Recommendation Report for Planning Permission for Works or Extension to a Dwelling

REF NO: P/19/19/HH

LOCATION: 193 Pagham Road
Pagham
PO21 3JX

PROPOSAL: Porch extension

sheet 1 a of 2

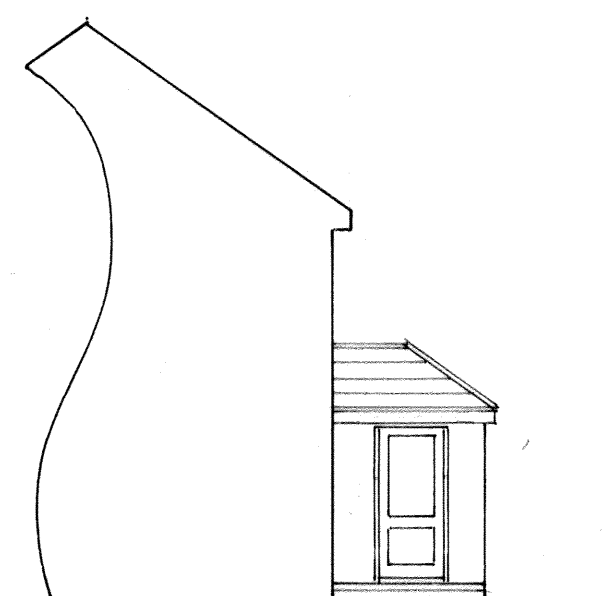
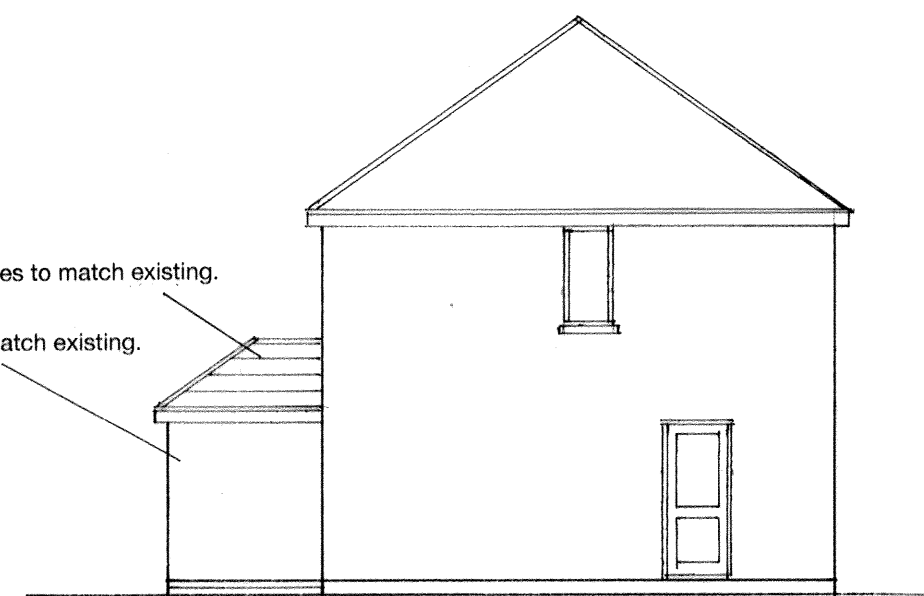
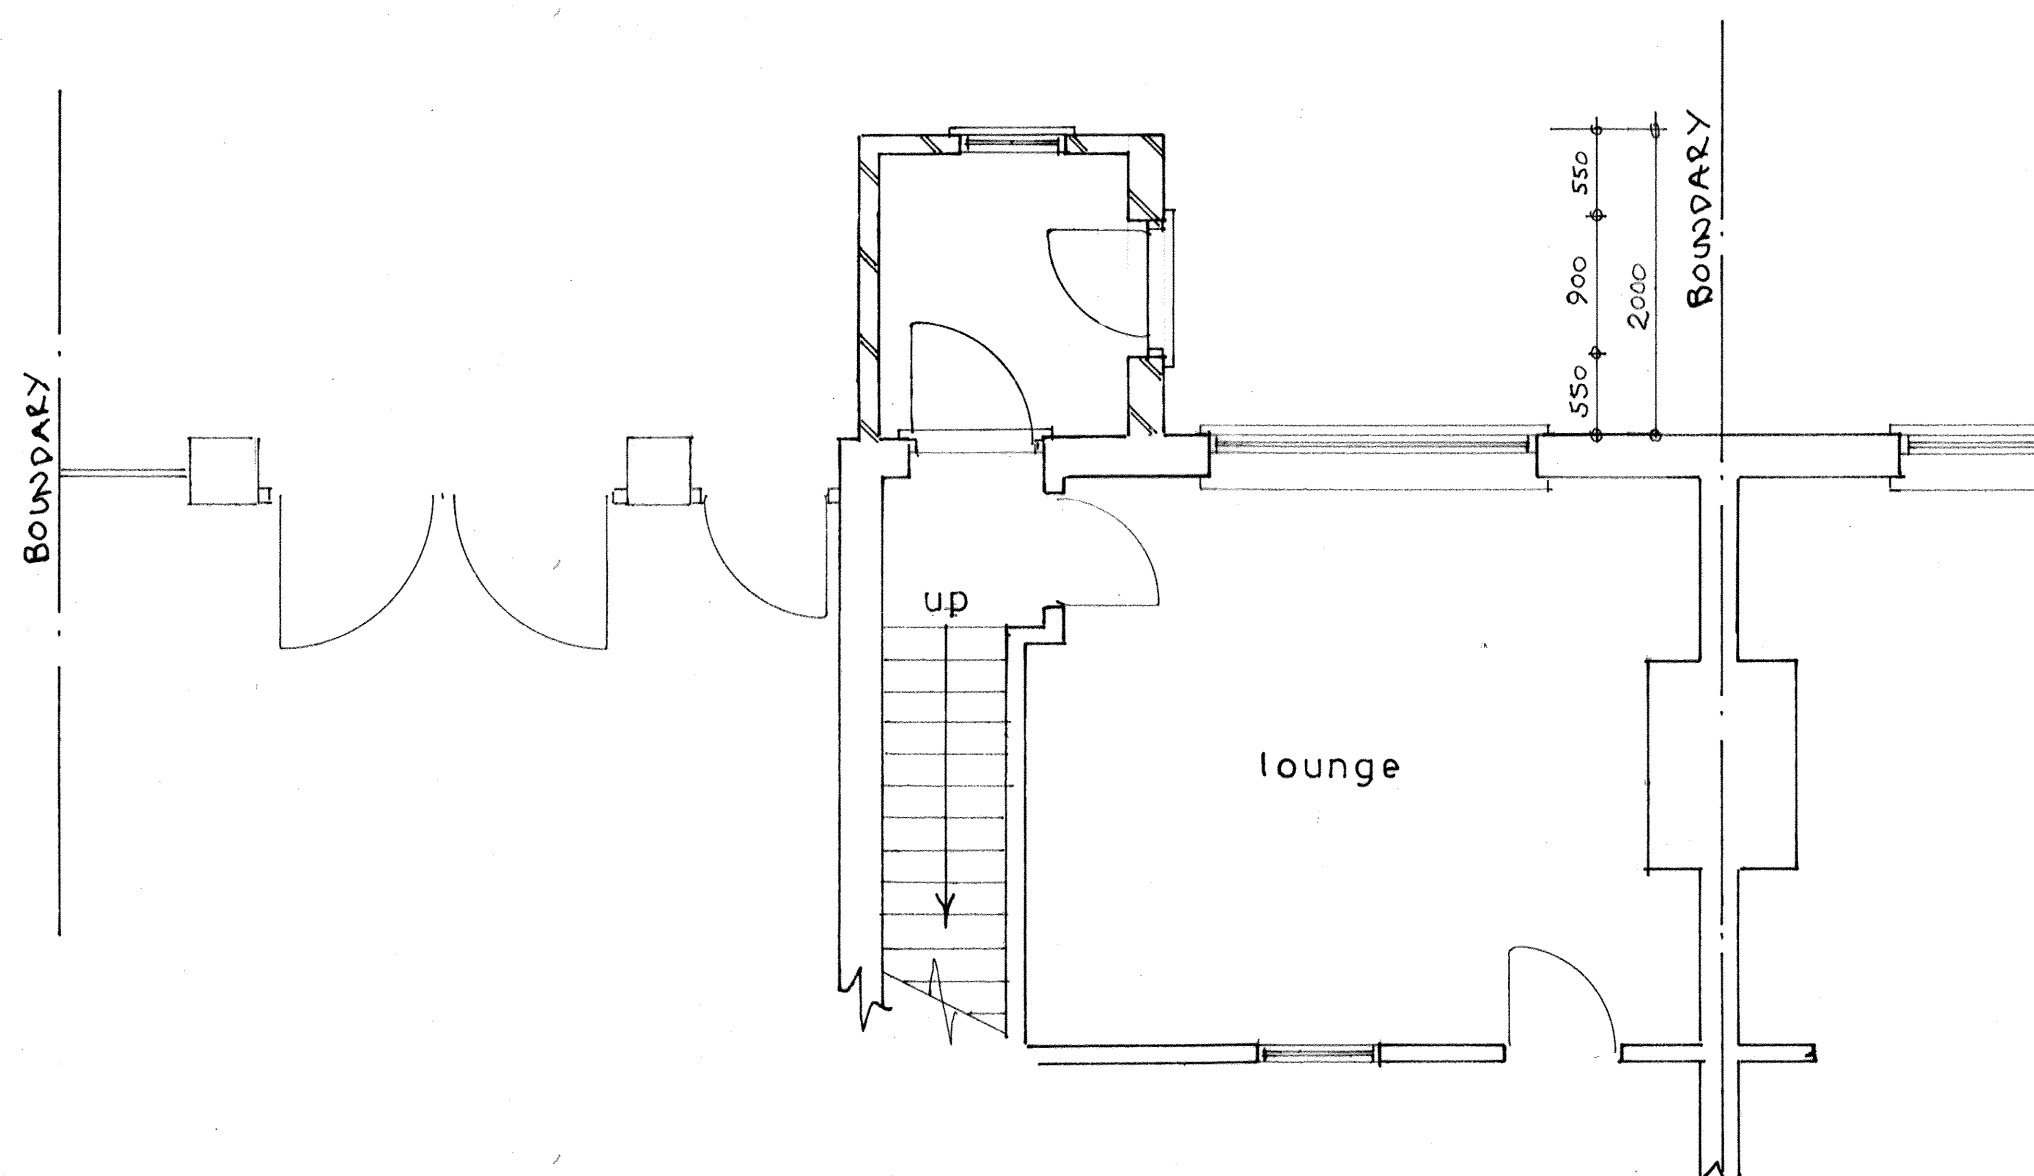
- position of the front door is a definite overview to our house, window, front door, driveway.

The proposed porch extension will be located approximately 5.5m from the Eastern boundary, 5.3m from the Northern boundary and 3.7 m from the Southern boundary. The proposed porch extension will feature 1No. window on the Eastern elevation and 1No. door on the Southern elevation. The window on the Eastern elevation is not considered to give rise to any additional overlooking given it is on the ground floor level and overlooking the road which is separated by the dwellings front garden. No windows have been incorporated on the Northern elevation to further mitigate any potential impact upon neighbouring properties.

The proposed distance between the door on the Southern elevation and the shared boundary line is approximately 3.7 m. Given the proposed distance from the proposed door and the boundary line it is considered the proposal will not give rise to any adversely harmful overlooking or loss of privacy to the neighbouring property (191 Pagham Road).
